From: Dawn Dyson [REDACTED]
Sent: 29 September 2020 09:52
To: Planning <Planning@arun.gov.uk>
[REDACTED]
Subject: Fwd: R/160/20/HH - objection

Objection to the current plans being submitted for the proposed alterations to 17 Sea Avenue as the following needs to be taken into consideration.

R/160/20/HH

PROPOSED EAST ELEVATION 1:100

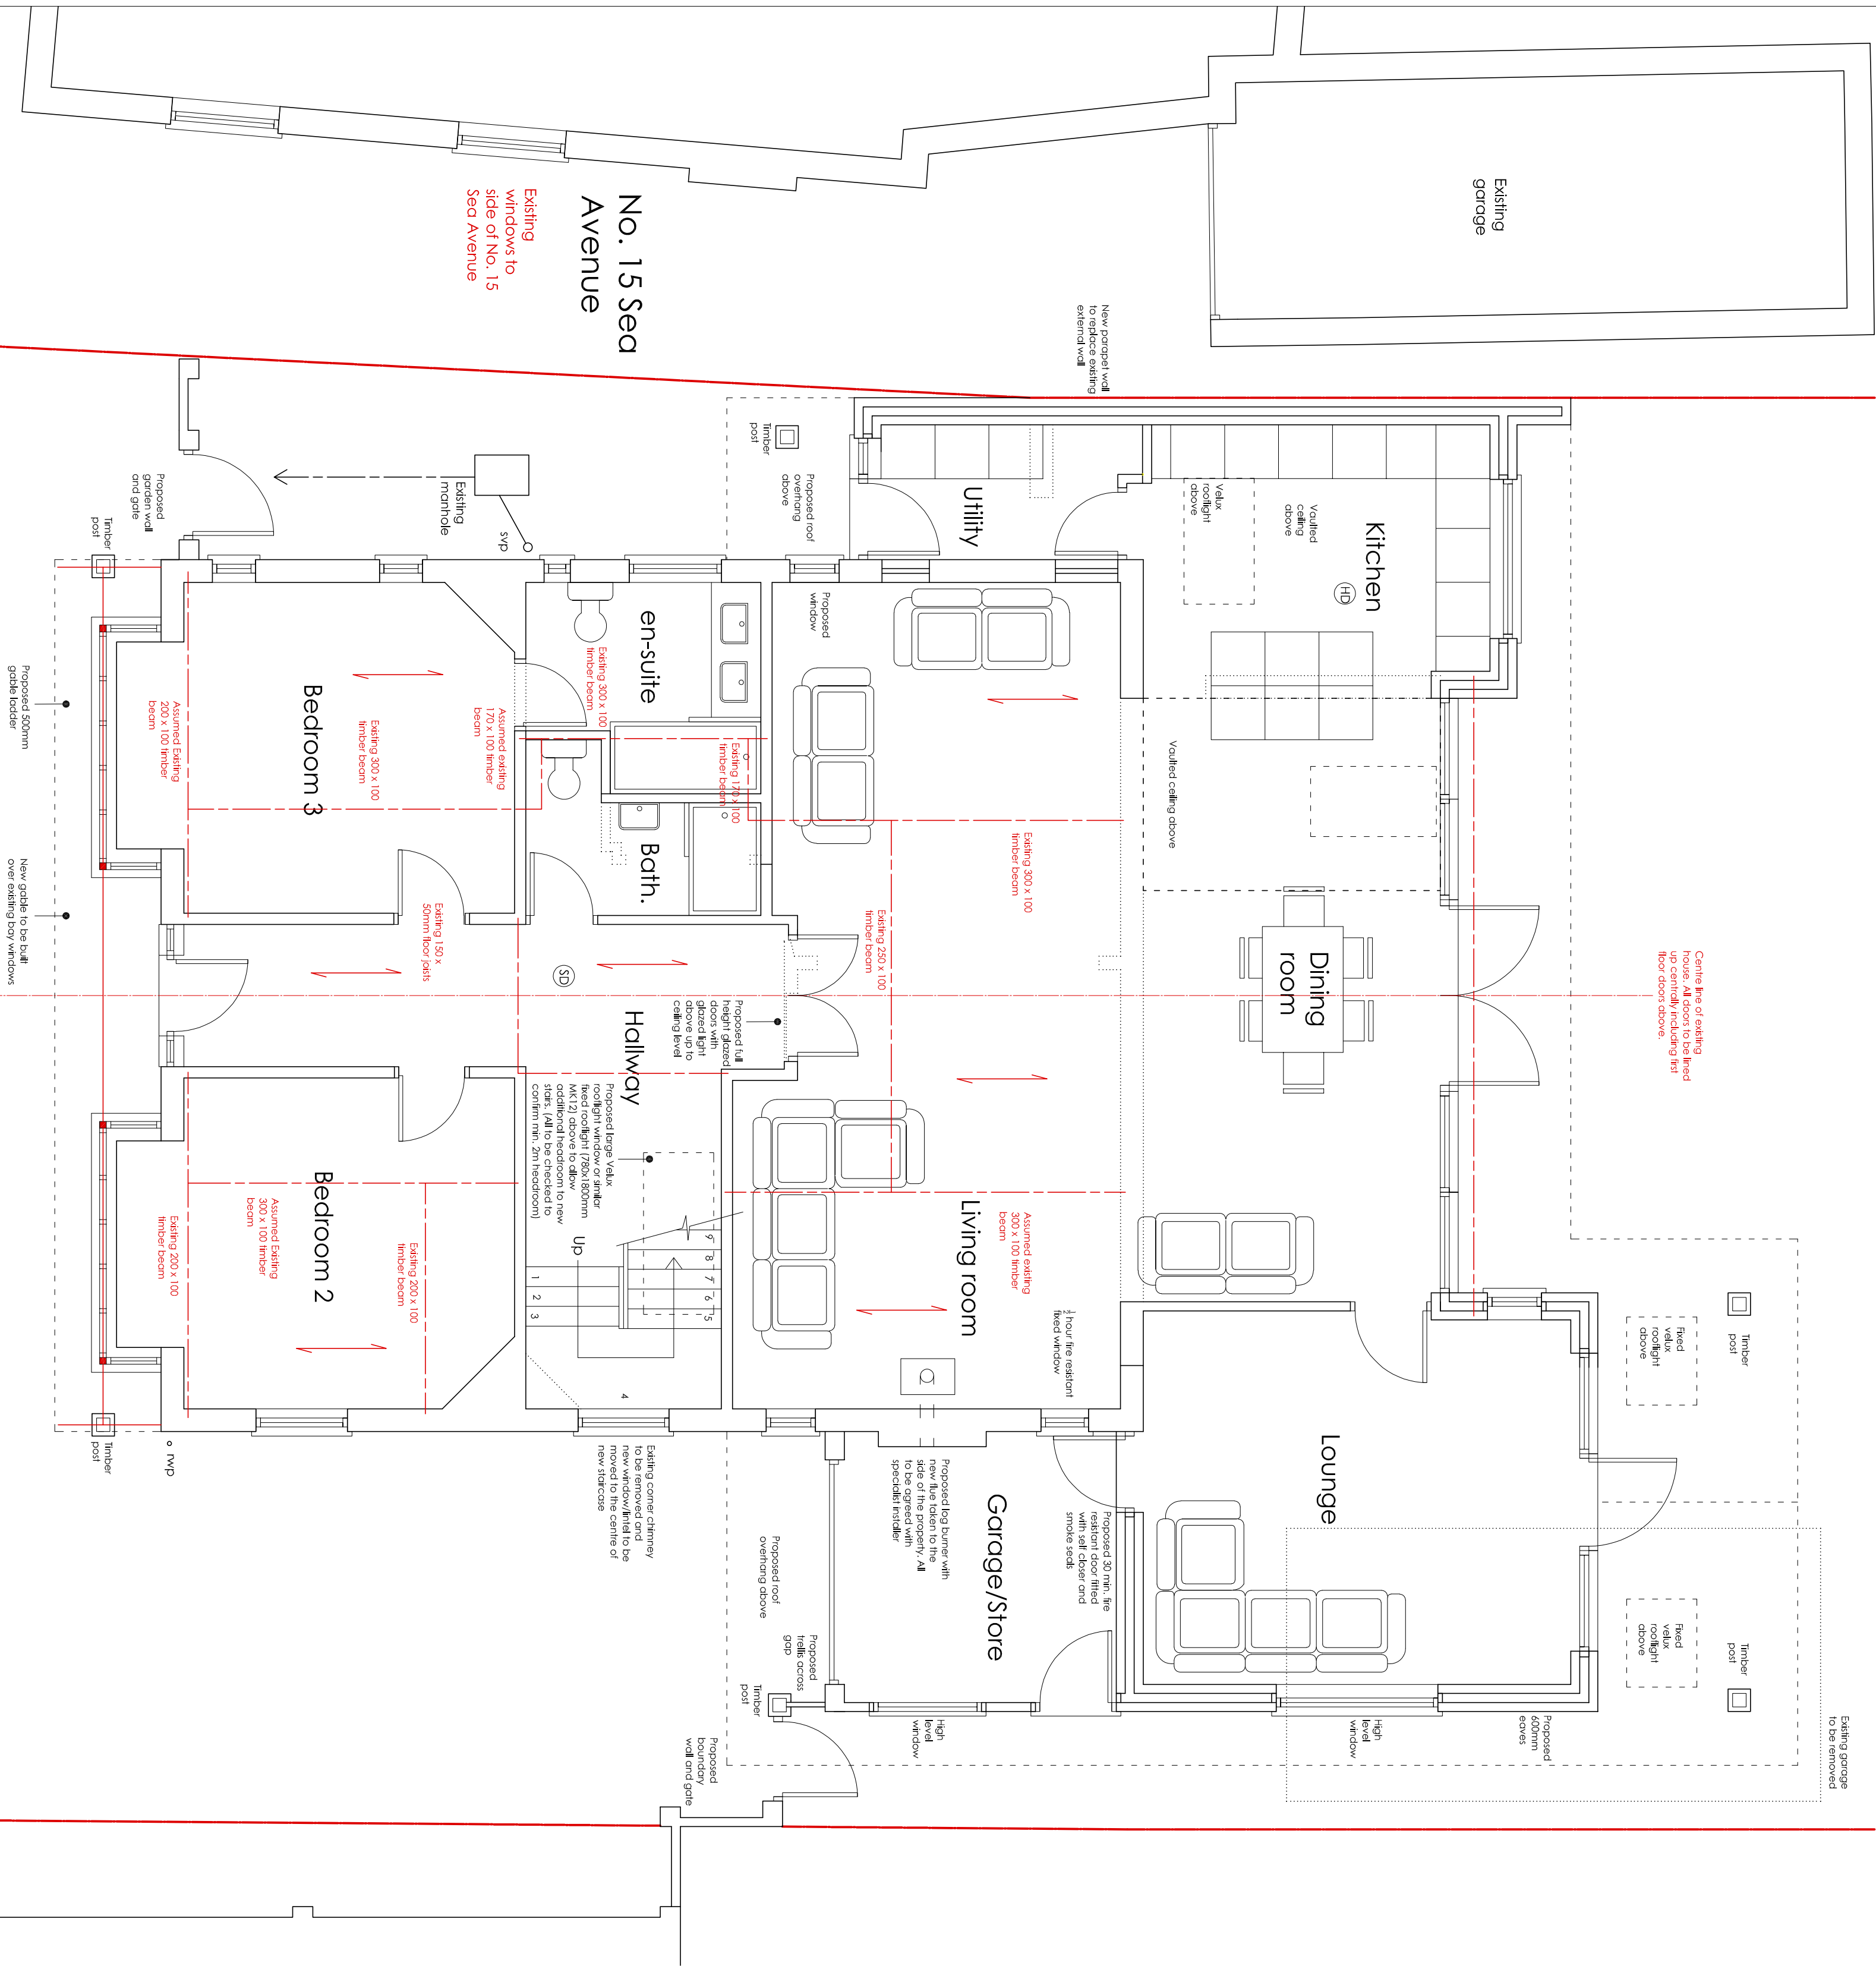
- 1) The proposed 1st floor balcony with double French doors and Velux roof lights on the east elevation will overlook a large area of the rear garden belonging to 15 Sea Avenue infringing on its current seclusion and privacy, this being a major change from the existing small opaque roof light.

PROPOSED NORTH ELEVATION 1:100

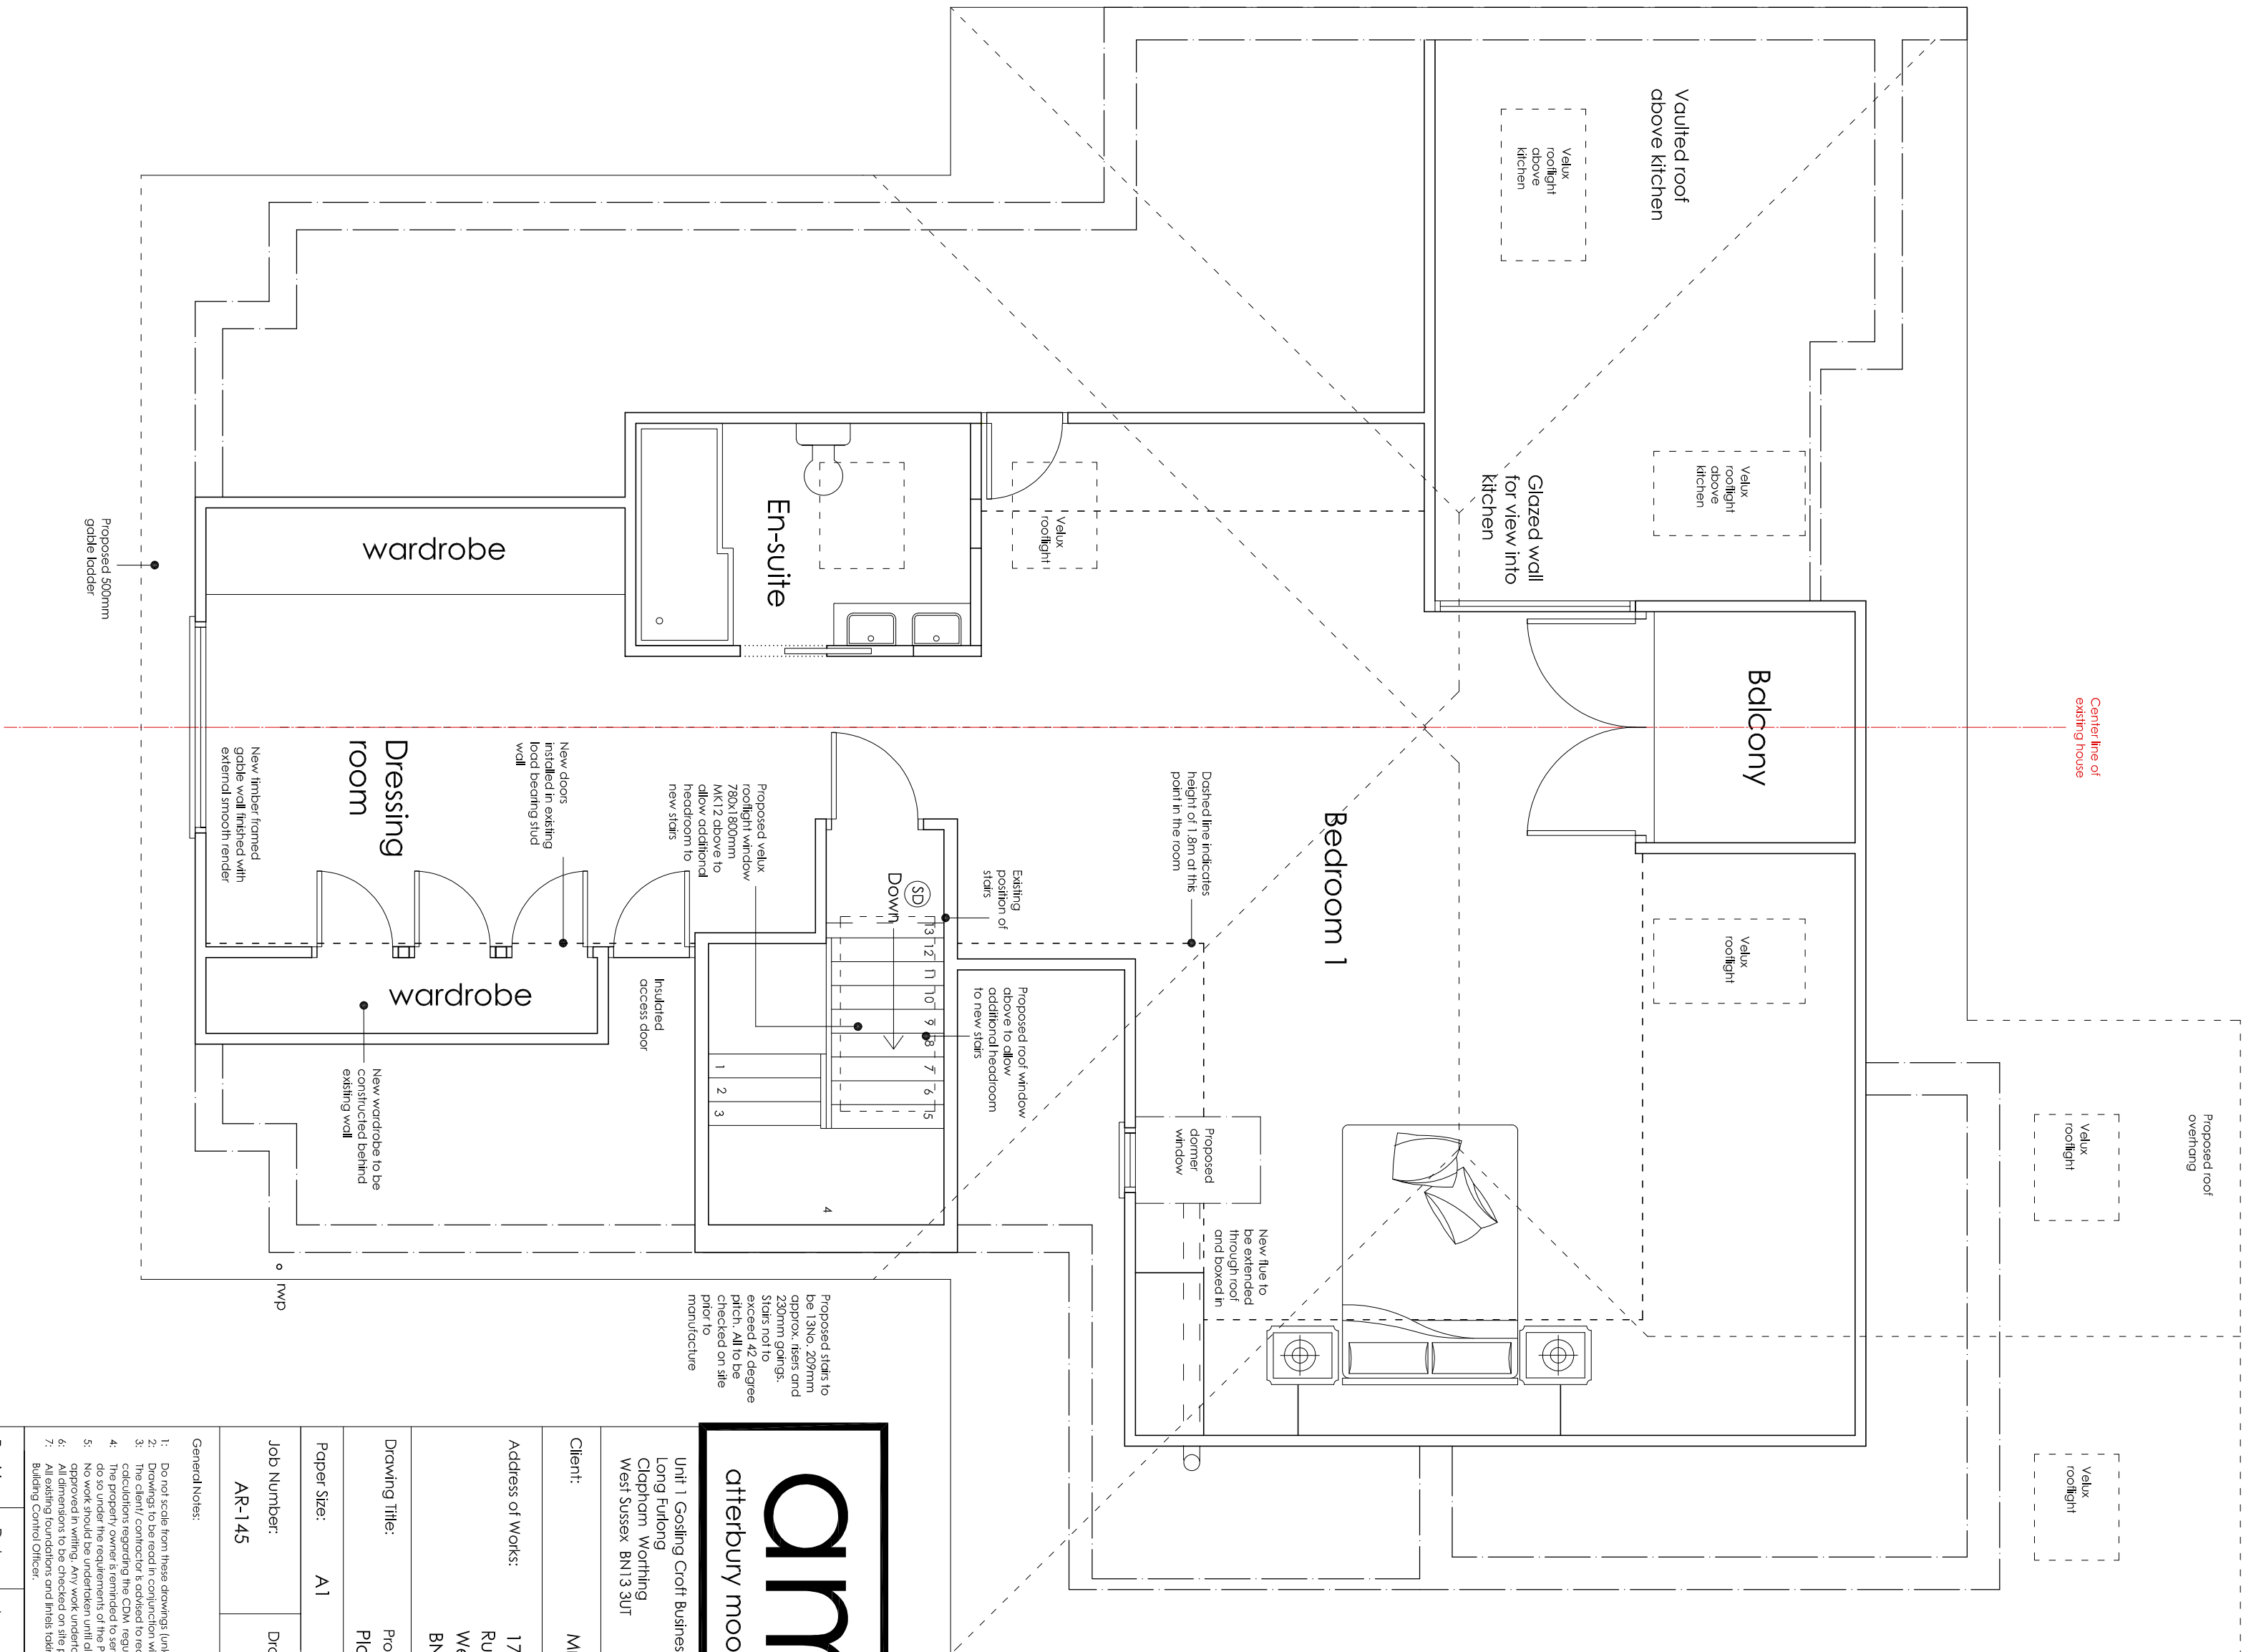
- 3) The existing lean to on the north elevation is set back from the boundary line. The replacement of the lean to by the proposed building works would further breach the boundary line. It is believed that responsibility for the boundary lies with 15 Sea Avenue.

- 4) The new parapet wall on the north elevation seems excessively high and will appear unsightly. Currently the two south facing lounge windows either side of the chimney breast have been decommissioned, however, should these be reinstated, they would face the proposed parapet wall. In addition, it will visually narrow the access to the garage of 15 Sea Avenue and potentially affect the property value.
